**Our Case Number: ACP-323830-25**

**Re:** Proposed flood relief scheme  
in Mountmellick, County Laois

TII25-133821

**RE: Proposed flood relief scheme in Mountmellick, County Laois**

Figure 1.5 - Flood defences, watercourses and bridges

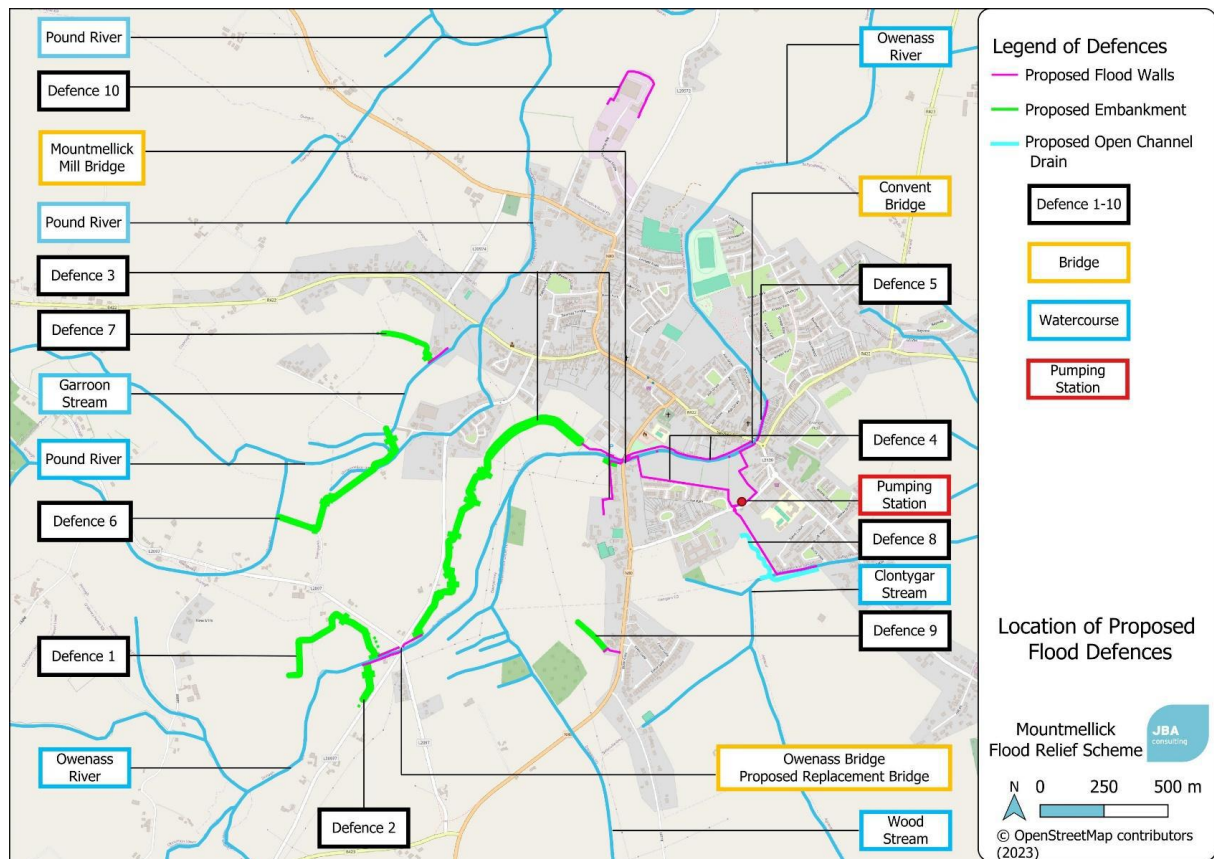
- a. Proposed "Defence 3", "Mountmellick Mill Bridge", and "Defence 4" as indicated at Figure 4-1: Flood defences, watercourses and bridges, of EIAR Chapter 4 Description of Proposed Development**

**b. Proposed "Defence 9" as indicated at *Figure 4-1: Flood defences, watercourses and bridges*, of EIAR Chapter 4 *Description of Proposed Development***

Proposed works at this location are indicated to consist of a proposed flood defence embankment and *"wall 16"* with new palisade security fence above extending to the edge of the N80. TII notes that no physical interactions with the N80 carriageway or associated services, such as drainage, are indicated as proposed in the submitted application. It is further noted that a potential construction site compound *"N"* is indicated immediately south of the proposed works at this location.

As indicated national road infrastructure, including drainage, is designed and provided for the national road network requirements only. Therefore, TII does not permit connections to national

road infrastructure, including that storm water drainage regime which is required and designed for the national road.

- Clarification with respect to arrangements associated with proposed "Defence 9" as indicated at *Figure 4-1: Flood defences, watercourses and bridges*, of EIAR Chapter 4 *Description of Proposed Development* to enable TII to ascertain that the proposal has been designed to operate independently and therefore ensure that infrastructure associated with the national road network, including drainage will be protected and maintained during the construction and operation of the proposed scheme.
- The Construction Traffic Management Plan (CTMP) to be prepared as part of the CEMP should specifically include TII amongst its primary stakeholders to ensure embedded mitigation of potential national road impacts.

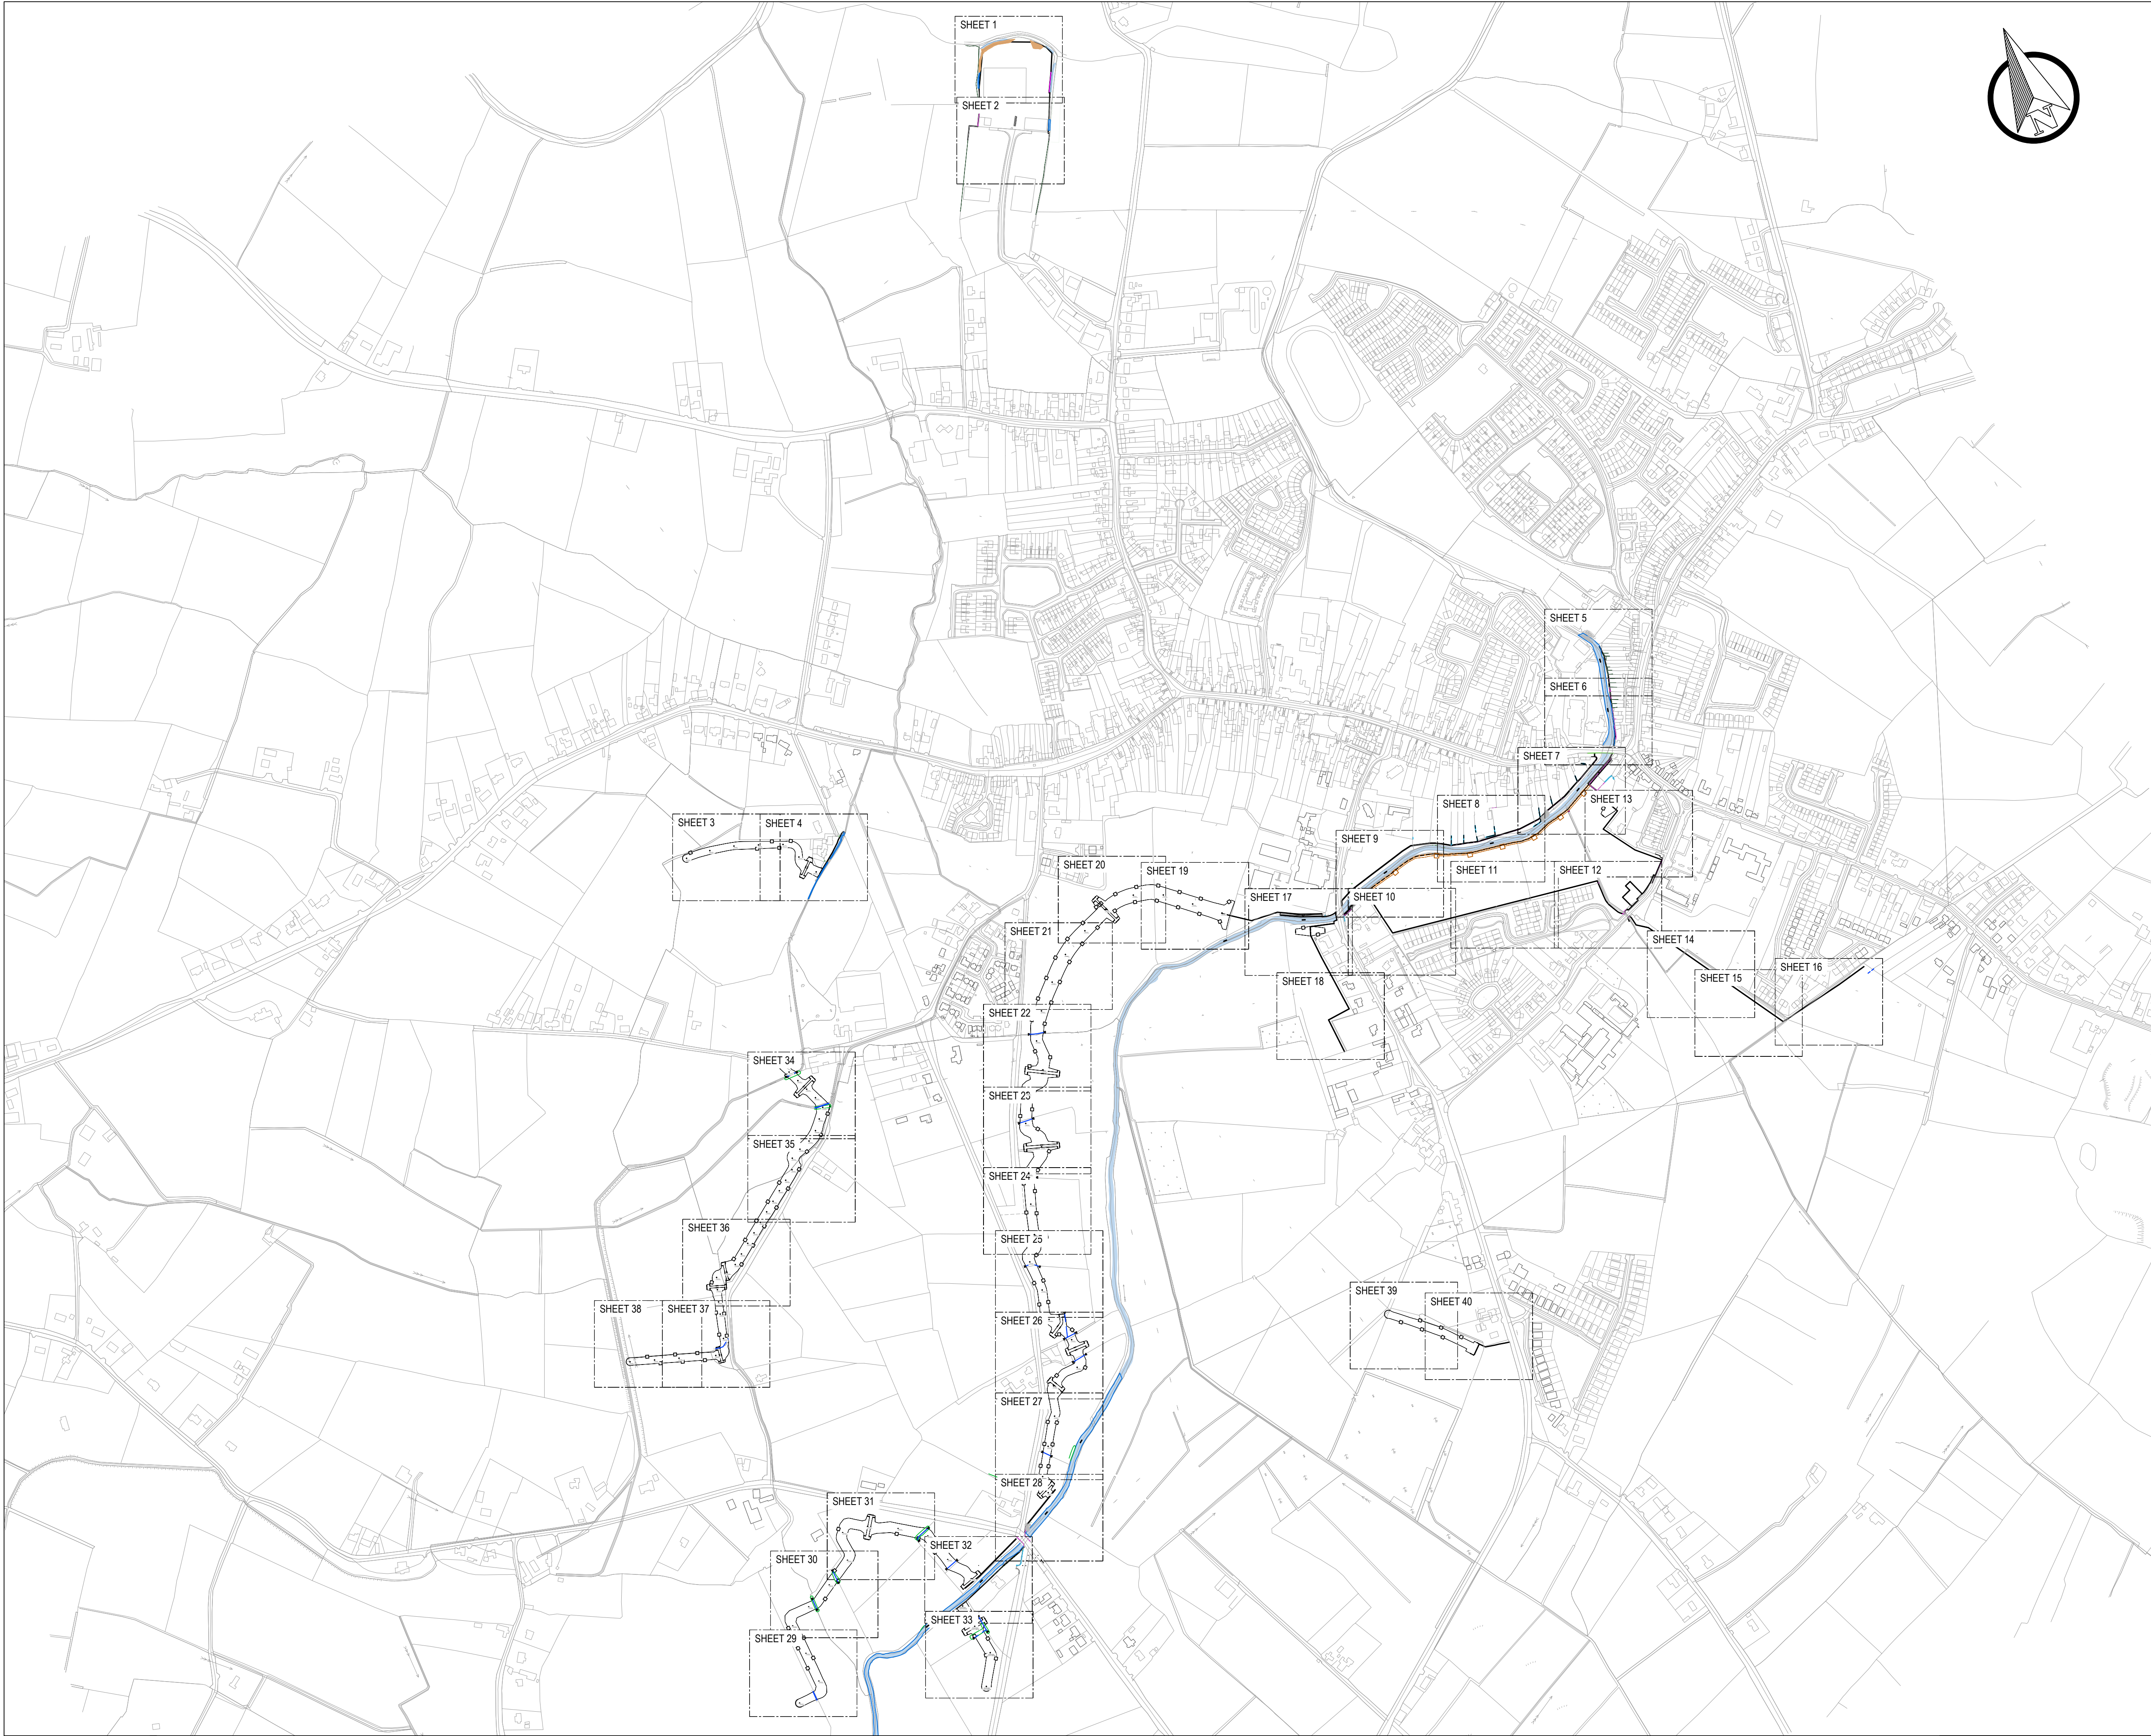
Works are indicated at Mountmellick Bridge on the N80 indicated on the *Site Layout Key Plan* (Drawing No. 19105-JBB-XX-XX-DR-C-02800, Rev. C01, dated 28.10.2025) as Sheet nos. 17 & 9.

It appears that proposed works on the immediate western side of the bridge and including the bridge are indicated to consist of the raising of the existing Owenass River north bank wall; raising of the bridge parapet; and removal, replacement and extension of the southern riverbank wall.

It appears that proposed works on the immediate eastern side of the bridge are indicated to consist of the installation of proposed "wall 5" on the northern bank of the river returning to the bridge; and the installation of proposed "wall 6" and "wall 7" to include replacement access ramp on the southern bank of the river at the bridge.

Mountmellick Bridge (EIAR named *"Mill Bridge"*) is part of the N80 and a TII Structure for which alterations are proposed as part of the FRS. Based on the information submitted as part of this application and TII's own records, no procedure under TII Publication *DN-STR-03001 - Technical Acceptance of Road Structures on Motorways and Other National Roads* has been undertaken in respect of Mountmellick Bridge (EIAR named *"Mill Bridge"*).

Therefore without recourse or verification from TII, the application does not include evidence of the undertaking of the procedures to be followed in order to obtain Technical Acceptance for structures on motorway and other national road schemes as required by TII Publication (Standard) *DN-STR-03001 - Technical Acceptance of Road Structures on Motorways and Other National Roads*. Due to the approach taken, TII must advise the Commission that it is unable to evaluate, substantiate and / or verify the design and mitigation approach of the application for proposed works to Mountmellick Bridge.

It is therefore TII's opinion that any decision associated with these proposals would be premature pending the advised undertaking of the technical acceptance procedures of TII Publication *DN-STR-03001 - Technical Acceptance of Road Structures on Motorways and Other National Roads*.

- Demonstration of compliance with TII Publications (Standards) in accordance with relevant TII Publications (Technical) will be required for any work that may impact the national road pavement, structures and infrastructure including drainage. In particular, any works to structures forming part of the national road network requires TII Technical Acceptance in accordance with TII Publication *DN-STR-03001*. For the avoidance of doubt, compliance with TII Publication *DN-STR-03001* is required to demonstrate the protection of the existing Mountmellick Bridge which is a TII Structure (Eirspan Name: *Mountmellick Bridge*, Eirspan ID: *LS-N80-009.00*).
